TRANSPORTATION MEMORANDUM

**Timbers at Black Forest
El Paso County, Colorado**

PCD File No. P269

April 2026

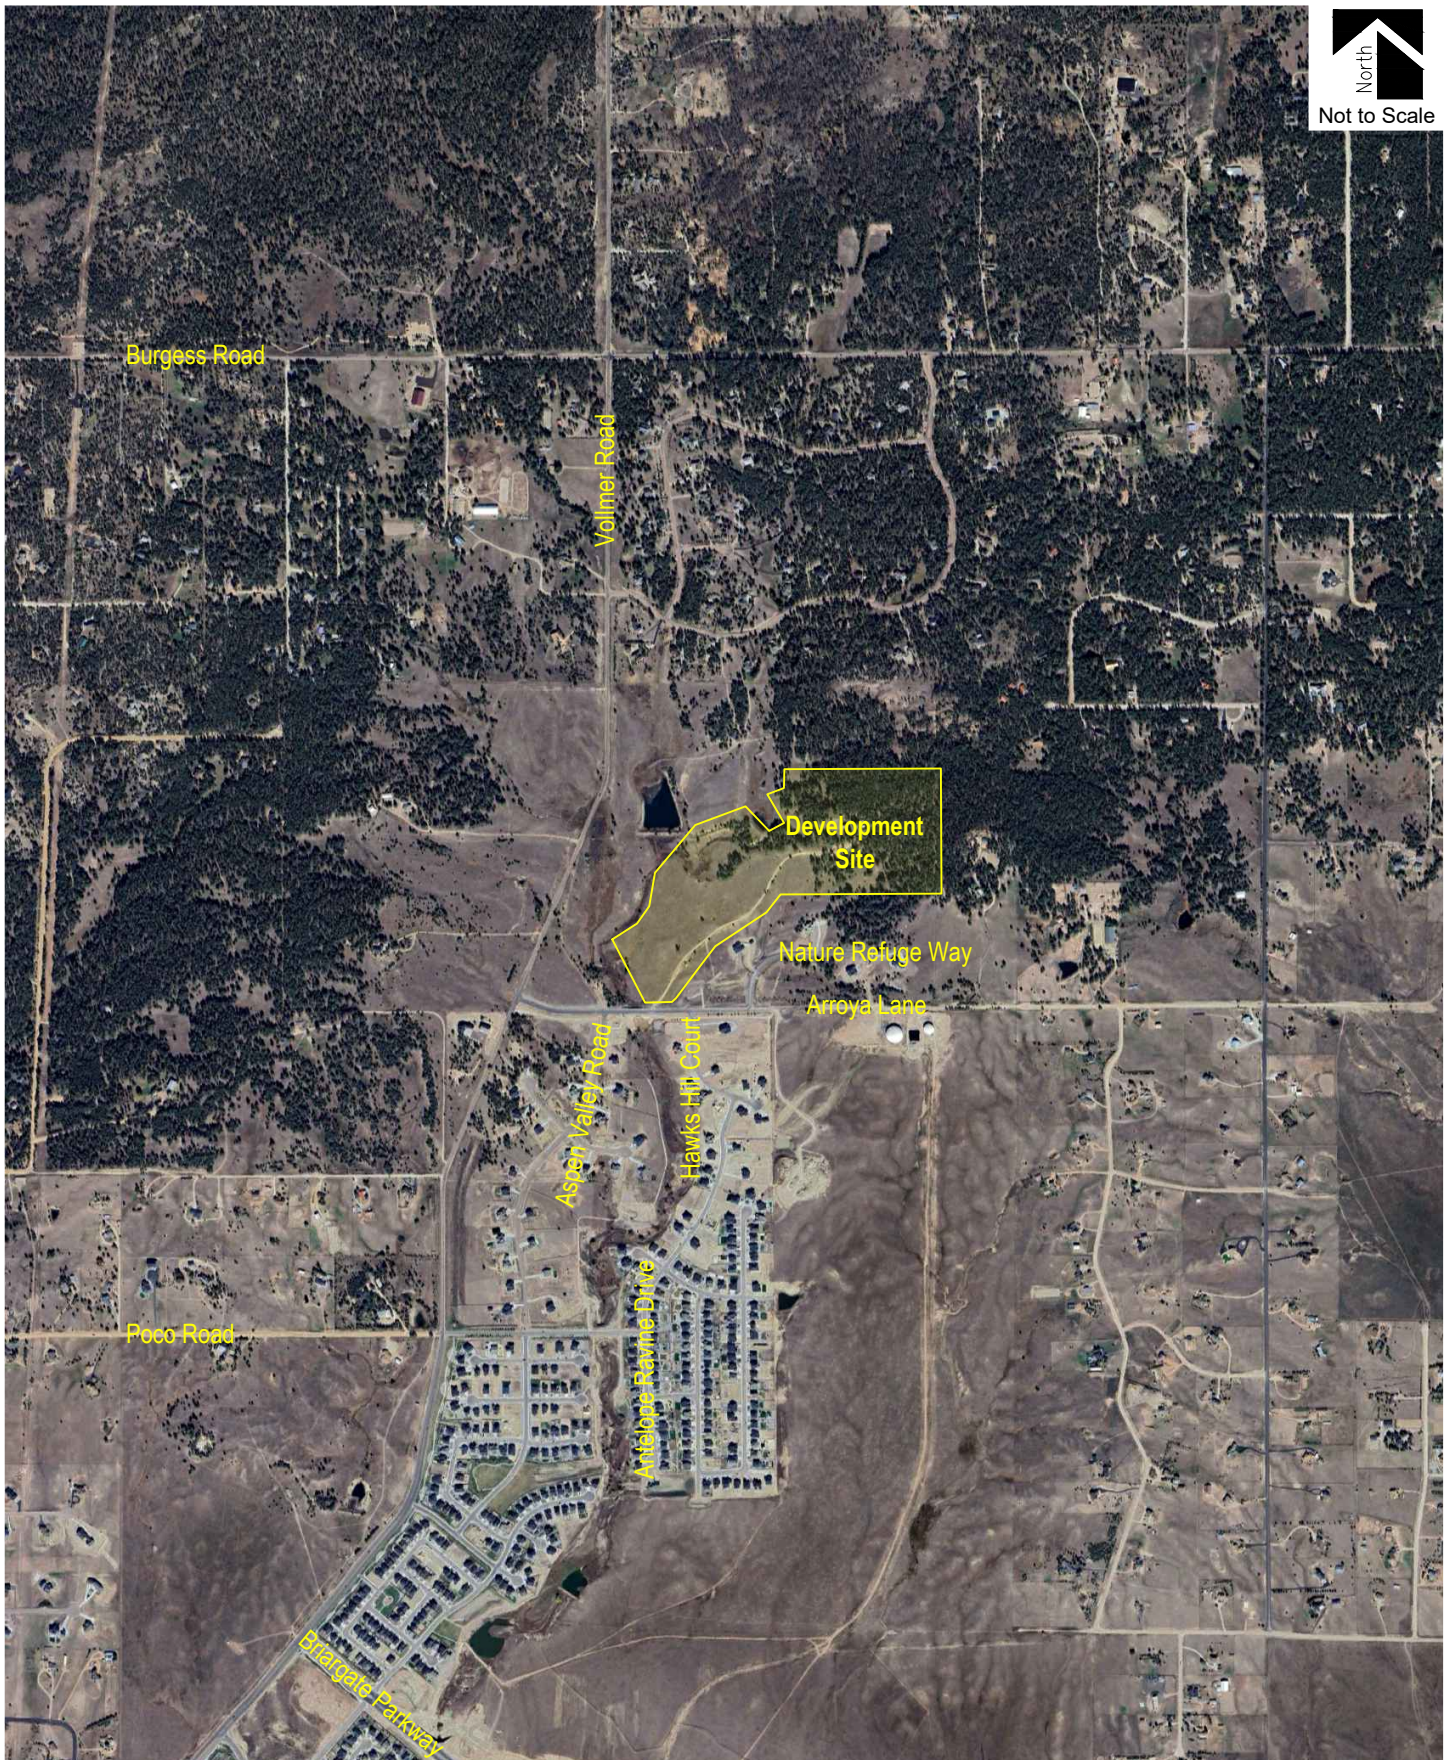
3 parcels exist and take access from the proposed roadway.; parcels to the north are land locked- do they have easements to this road? Does that take project over 25 lots?

Please refer to site civil (typ)

Proposed access to the development is provided via one full-movement access onto Arroya Lane (referred to as Site Access) located approximately 400 feet east of Aspen Valley Road and approximately 310 feet west of Hawks Hill Court.

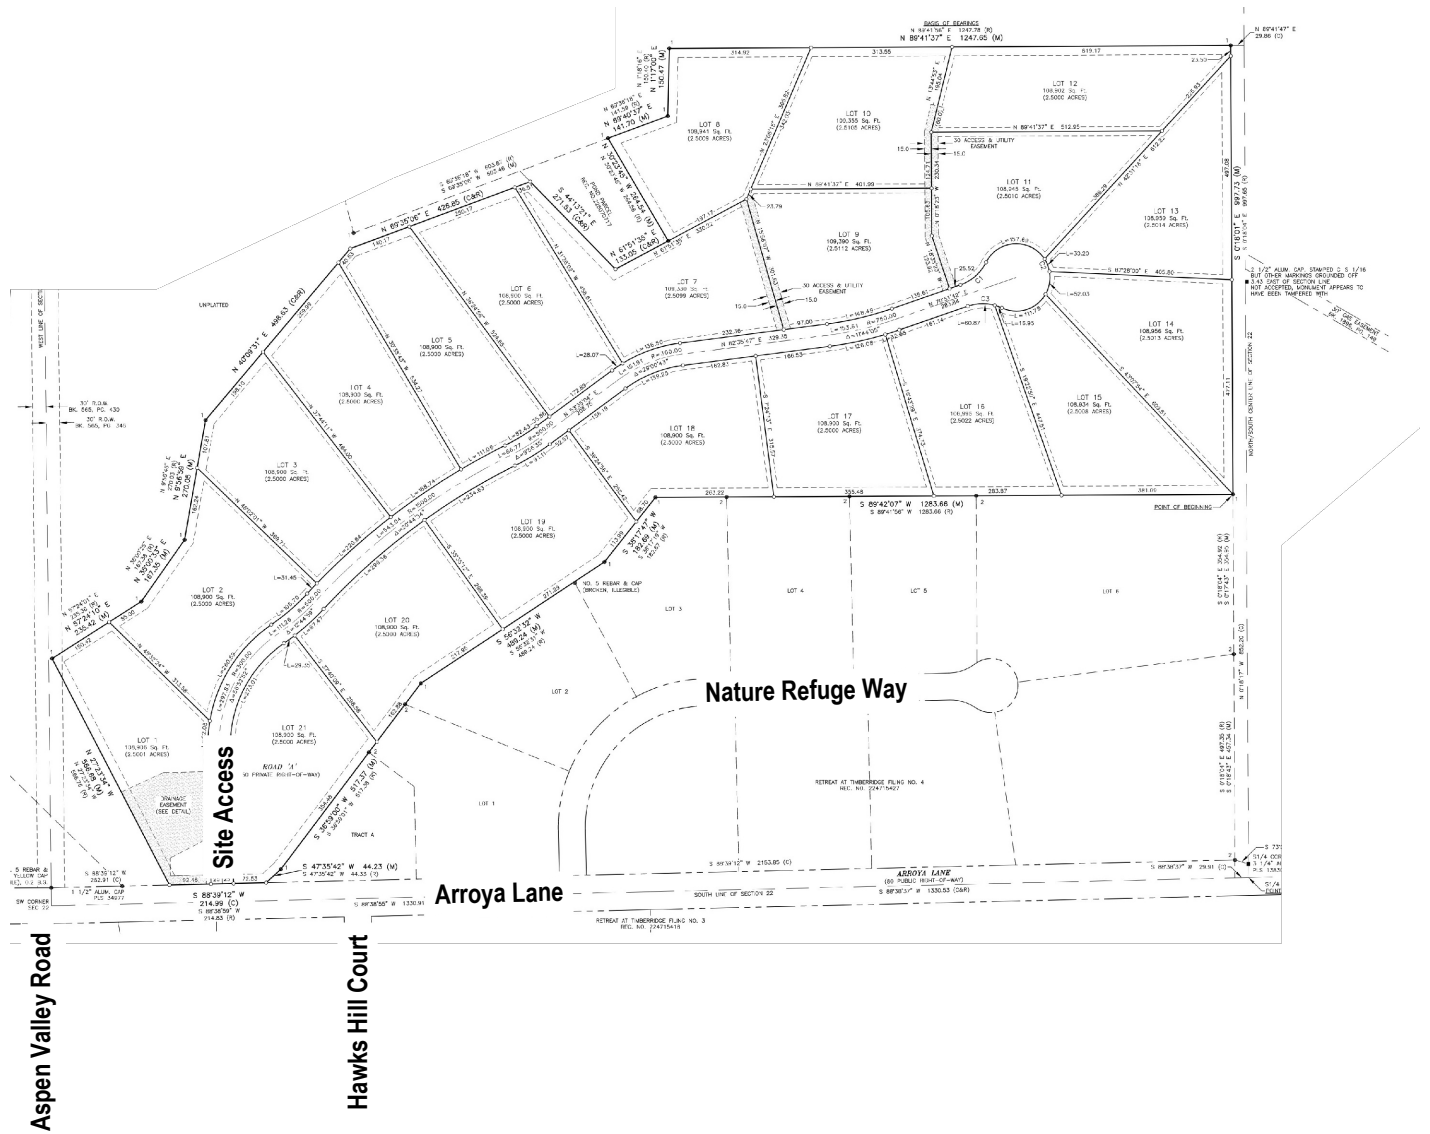
Note: The proposed access is located approximately 310 feet from the intersection of Arroya Lane (rural collector) and Hawks Hill Court (rural local road). This does not meet the minimum required 330-foot intersection spacing for rural local roads (per ECM Table 2-5).

A deviation request must be submitted to the ECM Administrator for consideration with the final plat application.

An additional deviation request will also be required for the access road itself. Cul-de-sacs shall have a maximum length of 1,600 feet for rural conditions. A request for deviation from the maximum length criteria will not be considered without an express written endorsement from the Fire District in which the cul-de-sac is located.

These deviations should be discussed in the version of the TIS submitted with the Final Plat. Comment acknowledged

Figure 4
BACKGROUND TRAFFIC - YEAR 2028
Volumes & Intersection Geometry
AM / PM Peak Traffic Hour
(ADT) : Average Daily Traffic

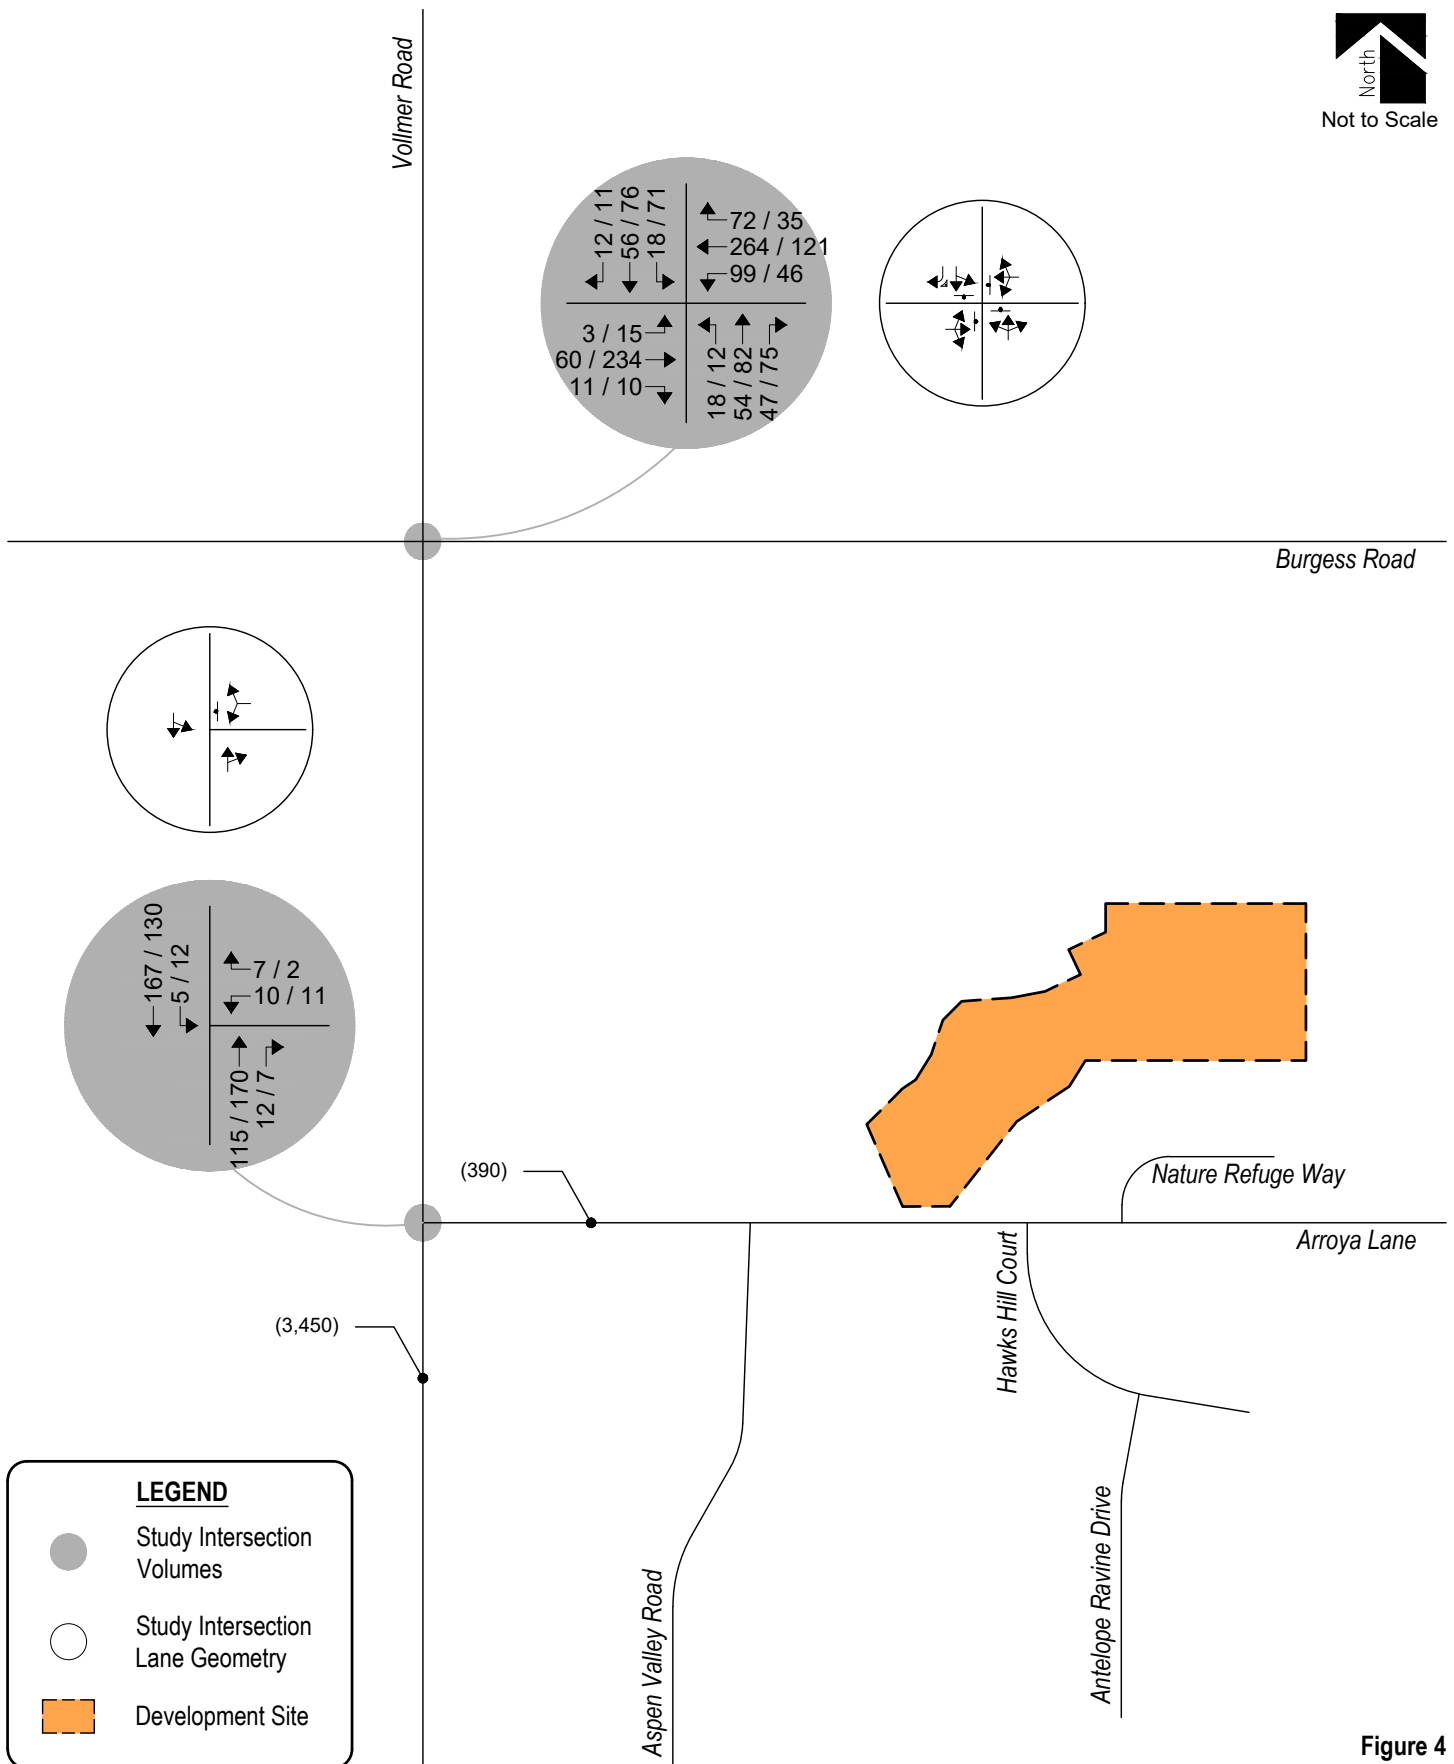
Indicate if Timber Ridge 3 is considered fully built out under existing conditions, or if it's not and a portion of it has been added into the future conditions.

Discussion added to Section II of this study
